RE: **Lot 7-A-1 6-A-1 Block 9 Unit 18 SAD 228**
6536 Papagayo NW
Volcano Cliffs Subdivision
Grading and Drainage Plan
Engineers Stamp Date 7/25/18 (D10D003I7)

RE: Lot 7-A-1 & Lot 6-A-1, Block 9, Unit 18, Volcano Cliffs Subd., SAD 228 (D10D00317)
6536 Papagayo NW

RE: **Lot & A-1 & A-1 Block 9 Unit 19 SAD 228
6536 Papagayo NW
Volcano Cliffs Subdivision
Grading and Drainage Plan
Engineers Stamp Date 7/19/18 (D10D003I7)**

ENGINEER'S SEAL	Title	DRAWN BY
	6536 PAPAGAYO NW	DATE
	GRADING AND DRAINAGE PLAN	Day
	RHD Engineering, LLC 4305 Purple Sage Ave. NW ALBUQUERQUE, NM 87120 (505) 288-1621	SHEET # 1 of 1
	Richard Dourte P.E. #10854	JOB #

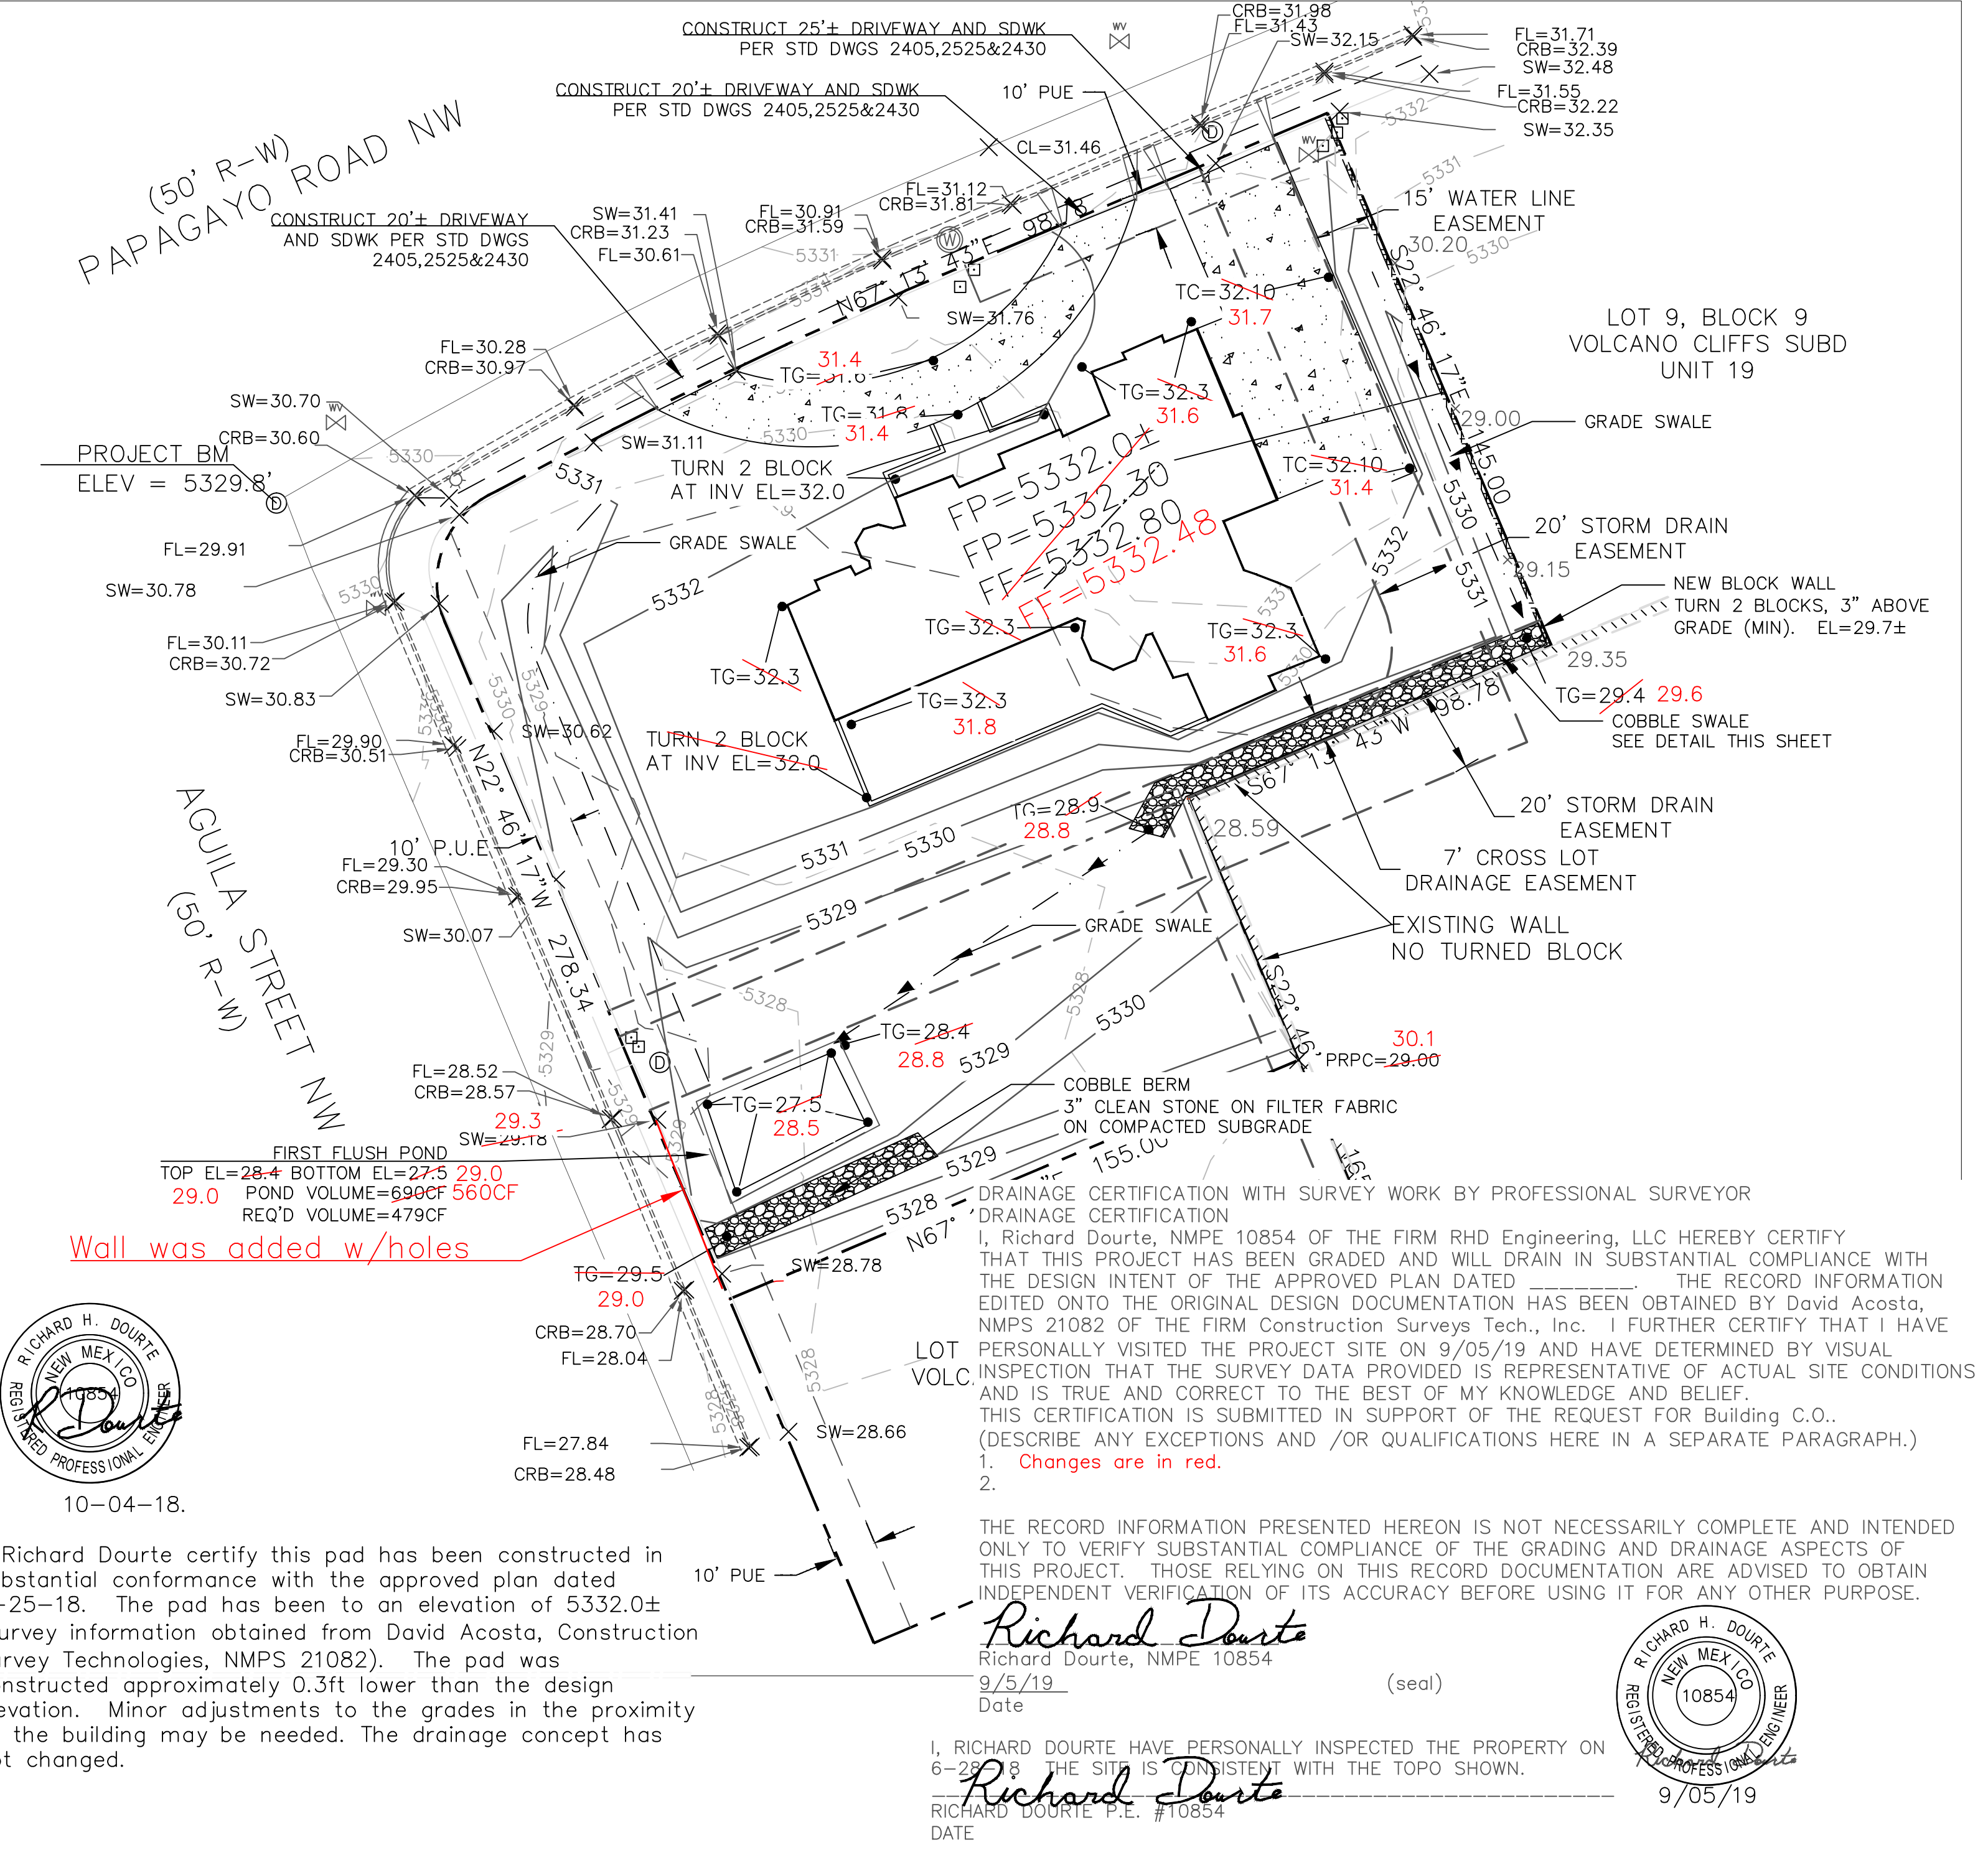
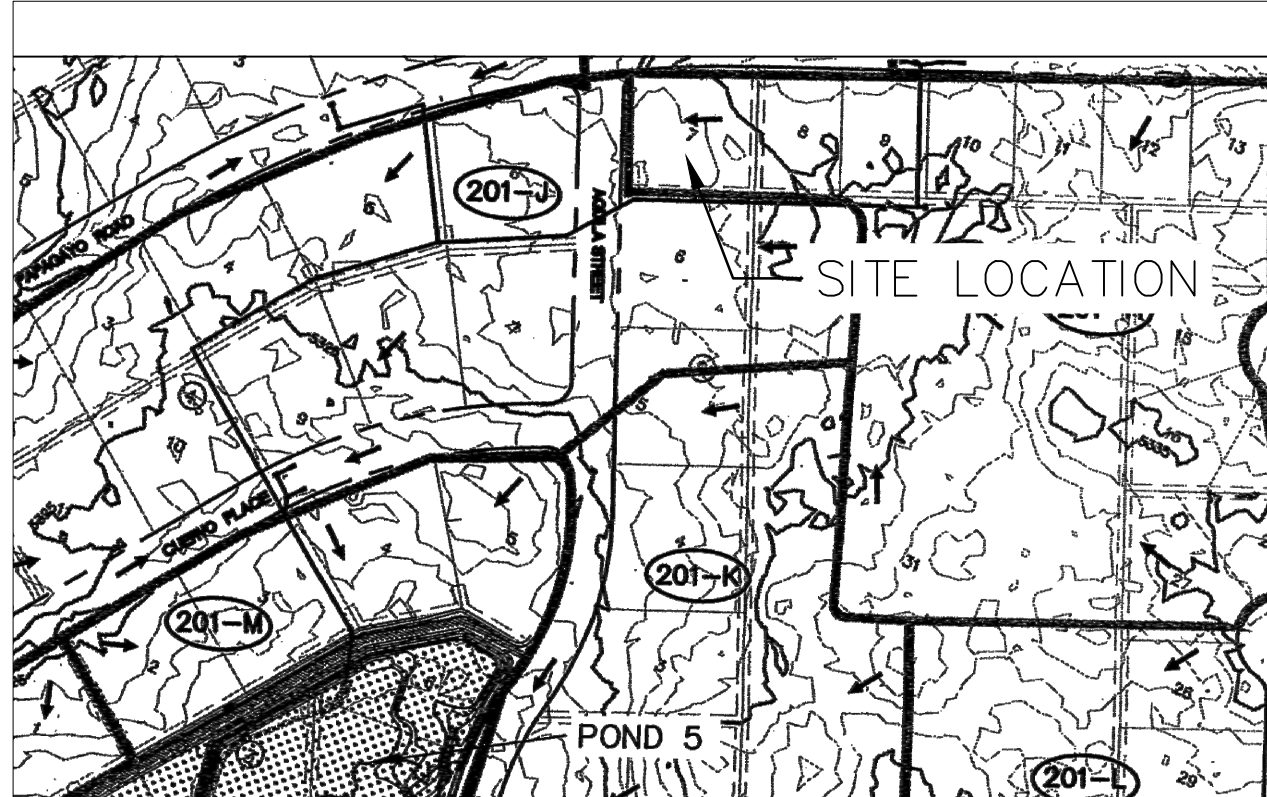
- In the cross section of the retaining wall show the location of the footing. If encroaching into adjacent lots a written letter of approval from the owner of the adjacent lot is required.
- Show the SS easement crossing between lots 6A & 7A. Construction is prohibited in the SS easement. A garden wall must not be built on top of the SS line. If the owner wishes to build near the SS, advise the owner, if the SS needs to be worked on or replaced, the garden wall may be removed or damaged and the owner will replace the wall at their cost, not at the cost of the COA.

1. The cross section now shows the foundation for the wall to be contained onsite with a note "Footing for wall to be located onsite, otherwise a written letter of approval from adjacent/impacted property owner is required"
2. The storm sewer easement is clearer on the drainage plan. A copy of the recent replat has been included for your convenience. Presently there is a substantial retaining wall located on the property line between this site and the existing subdivision south of this site. The linework for this wall has been redone. No new walls are proposed to be placed on the existing 20' storm drain easement.
